Our ref: TR010064/Deadline 5

### **TR010064 - M60/M62/M66 Simister Island Interchange EXAMINATION DEADLINE 5 SUBMISSIONS**

FIGURE 2.3

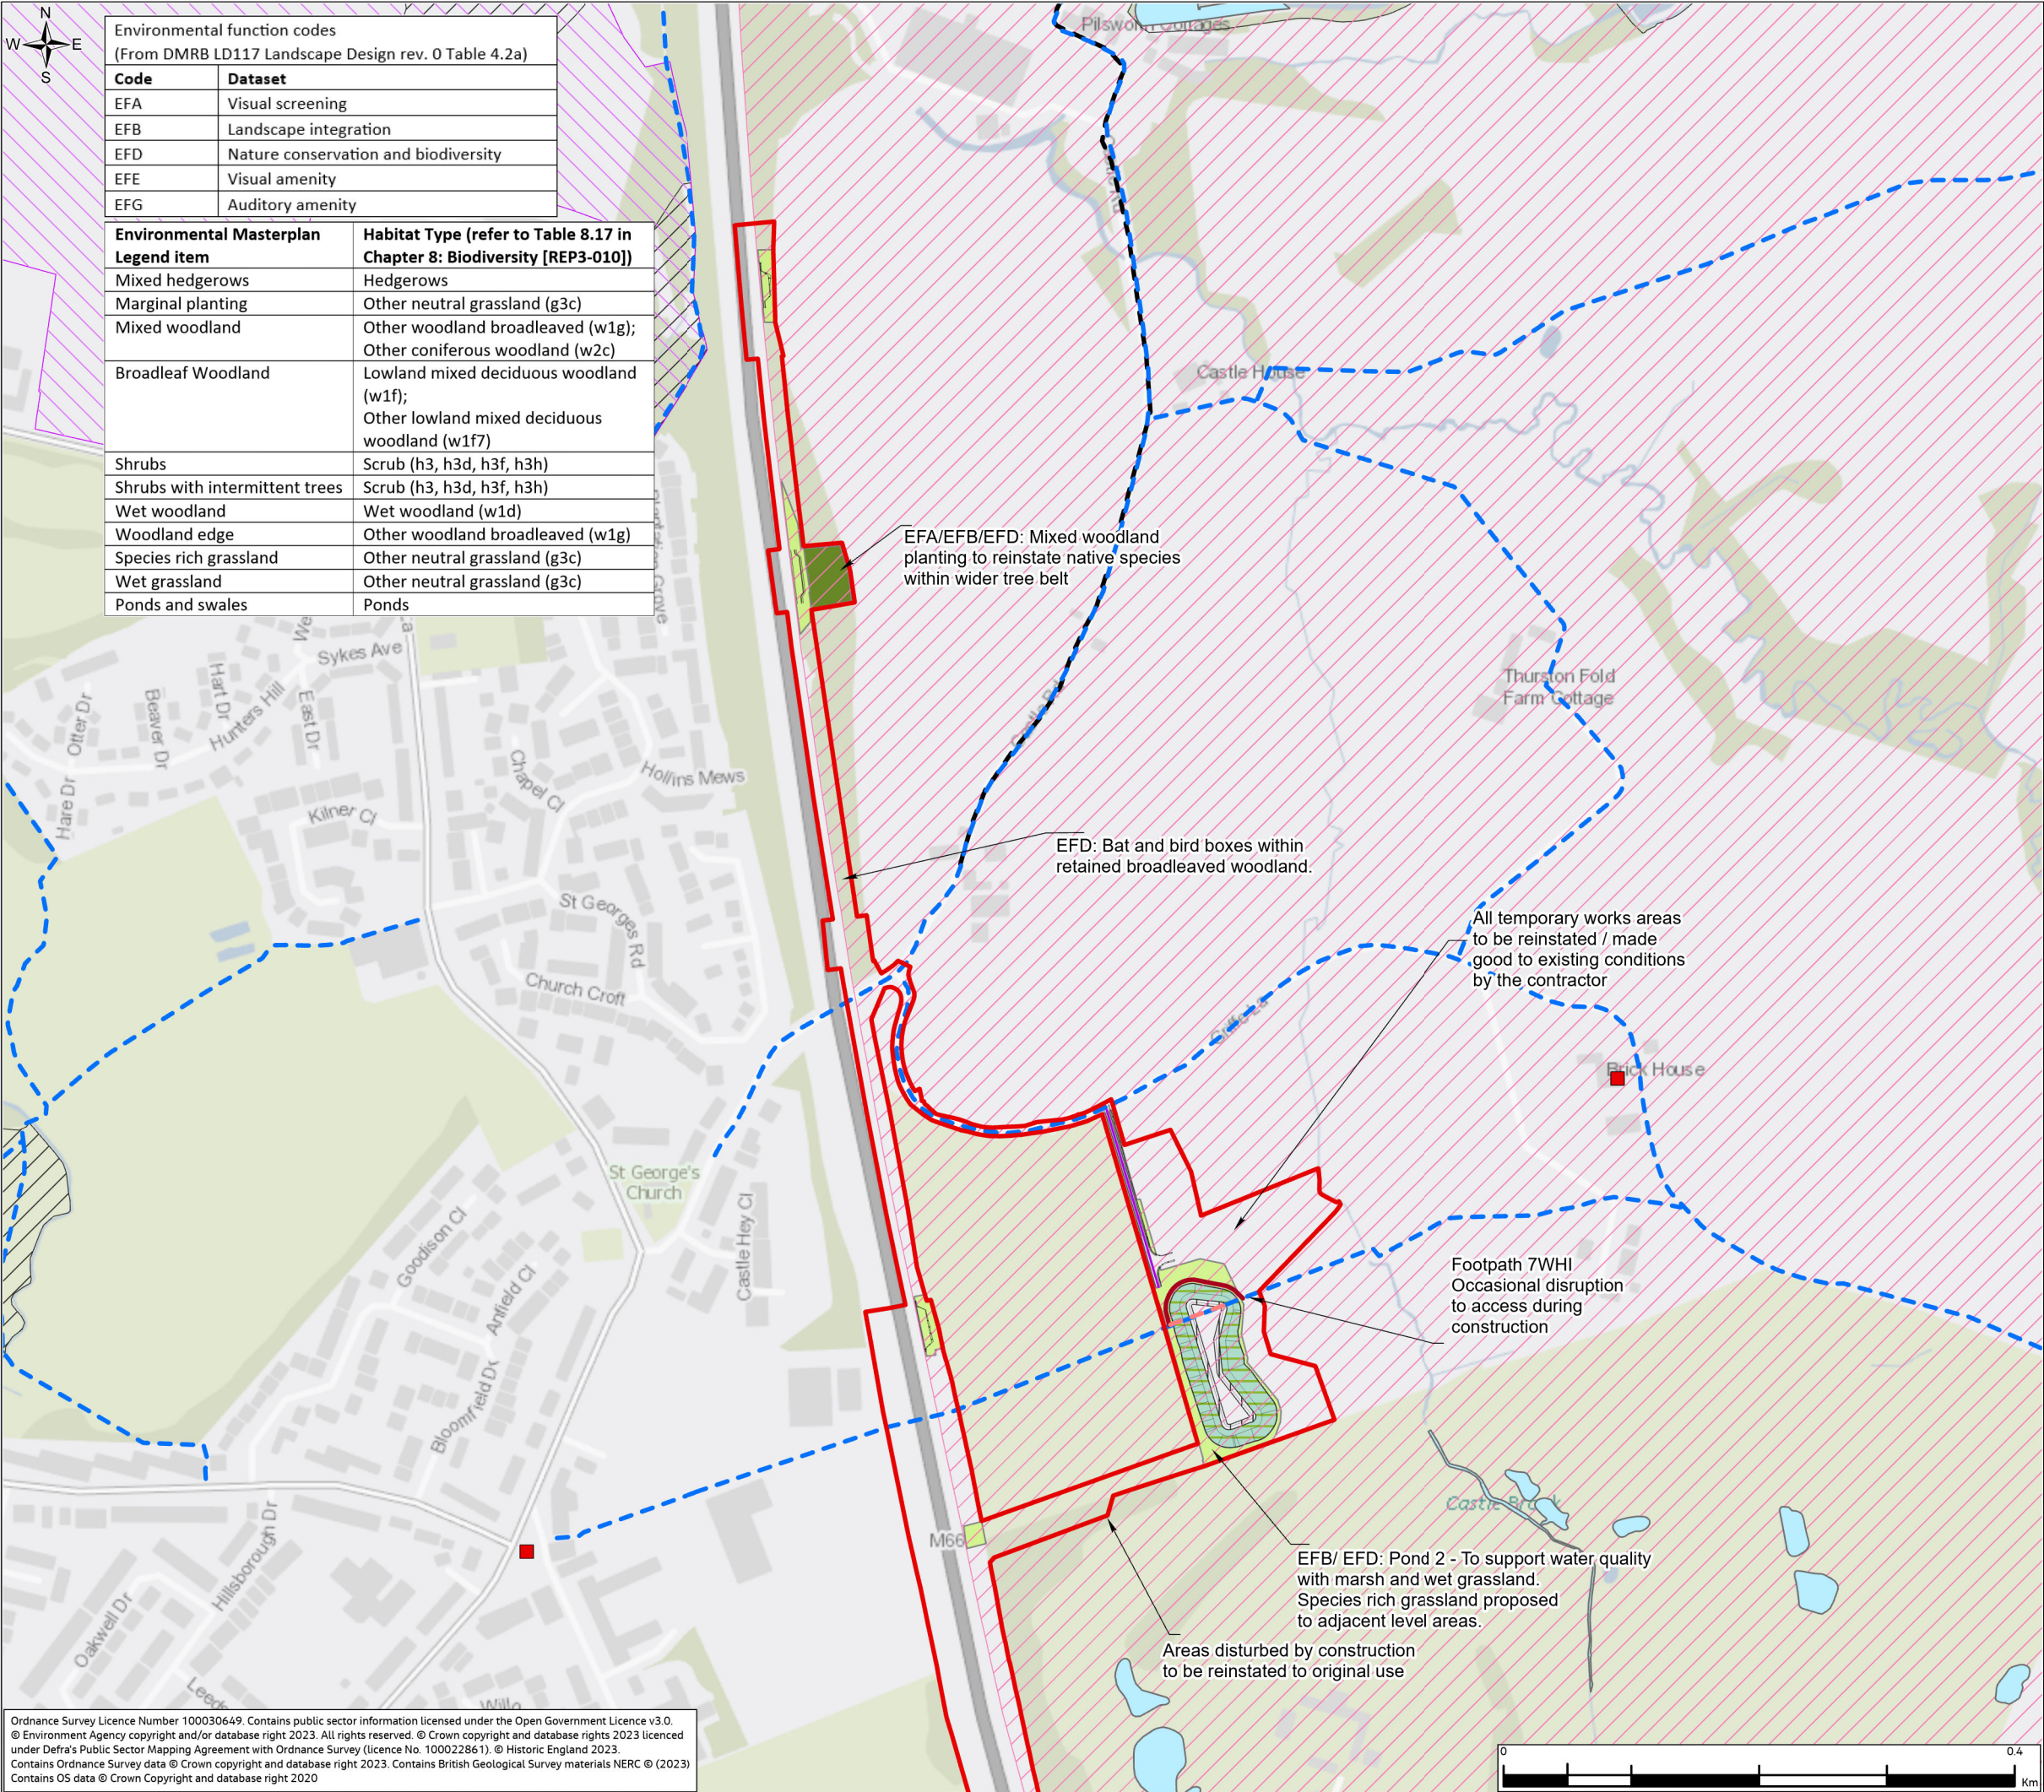
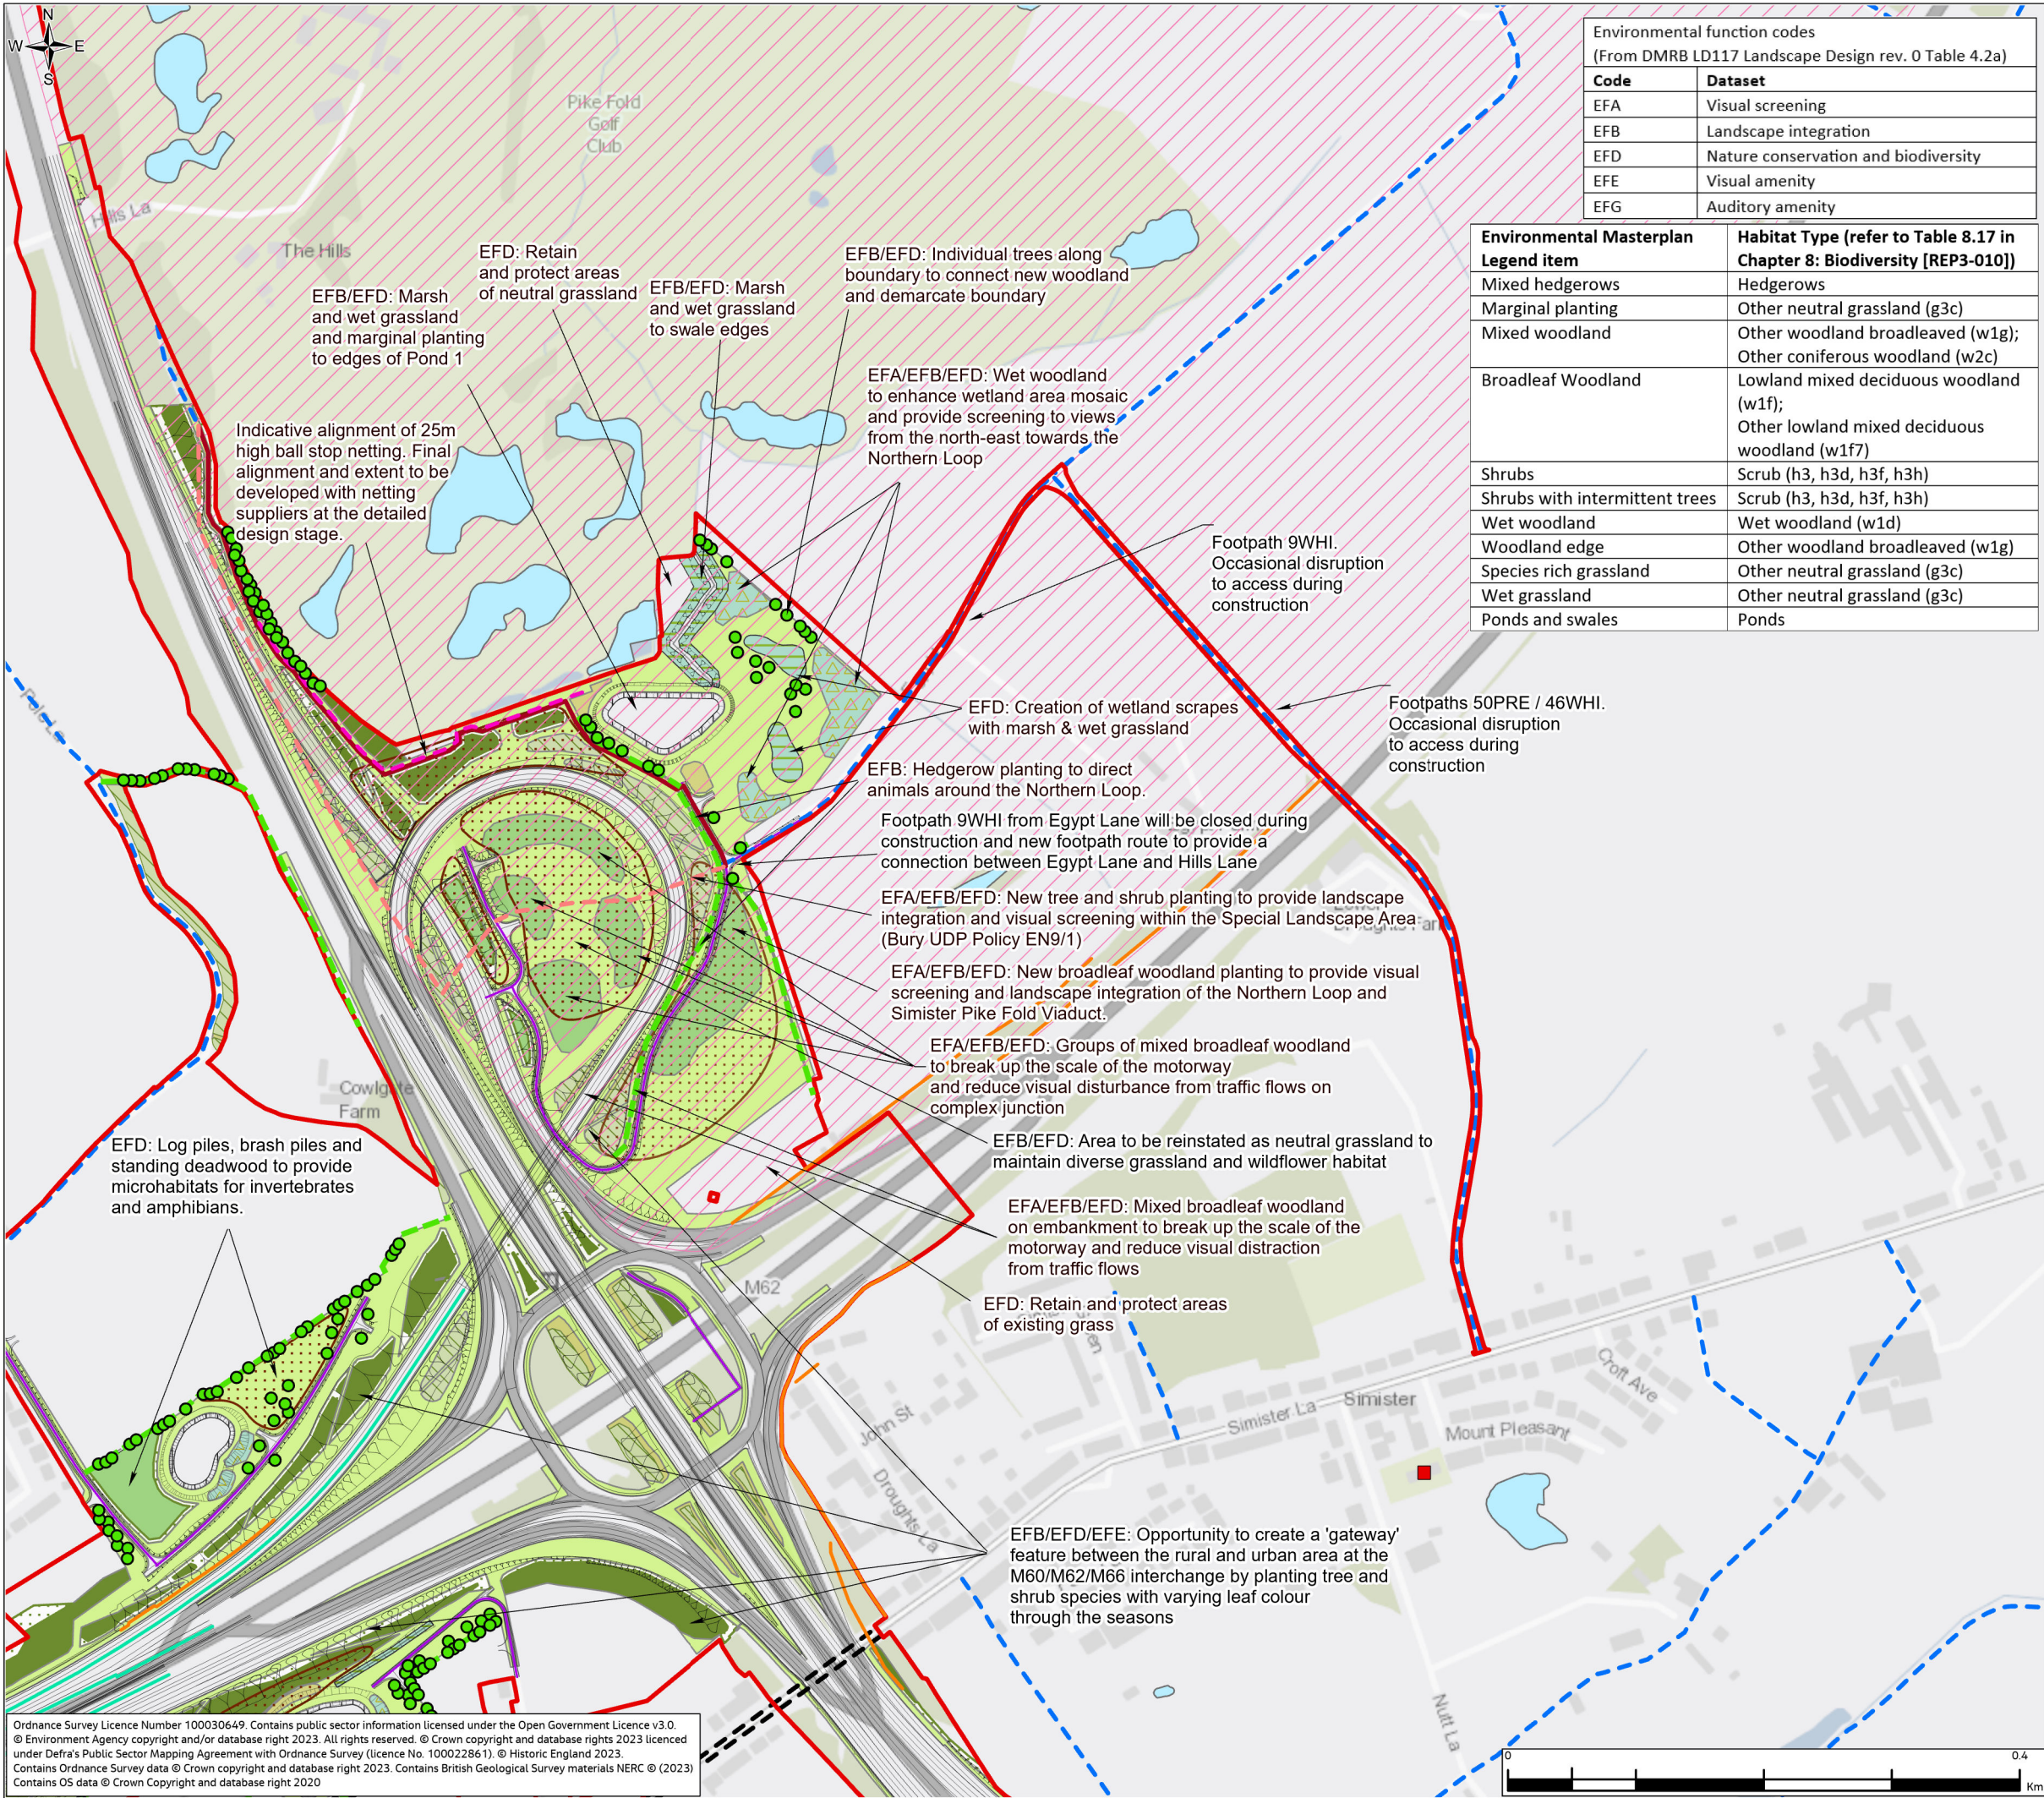
In responding to ExQ2 BIO.2.2 relating to Habitat Loss and Habitat Gain the Applicant has reviewed Figure 2.3 Environmental Masterplan of the Environmental Statement Figures [APP-057]. To assist with the interpretation of the Environmental Masterplan a table has been inserted to clarify which habitat type relates to which landscape description.

In undertaking this review the Applicant identified that the extent of the noise barriers and that of Public Right of Way 9WHI was not fully in alignment with the existing and so has been amended to the correct extent.
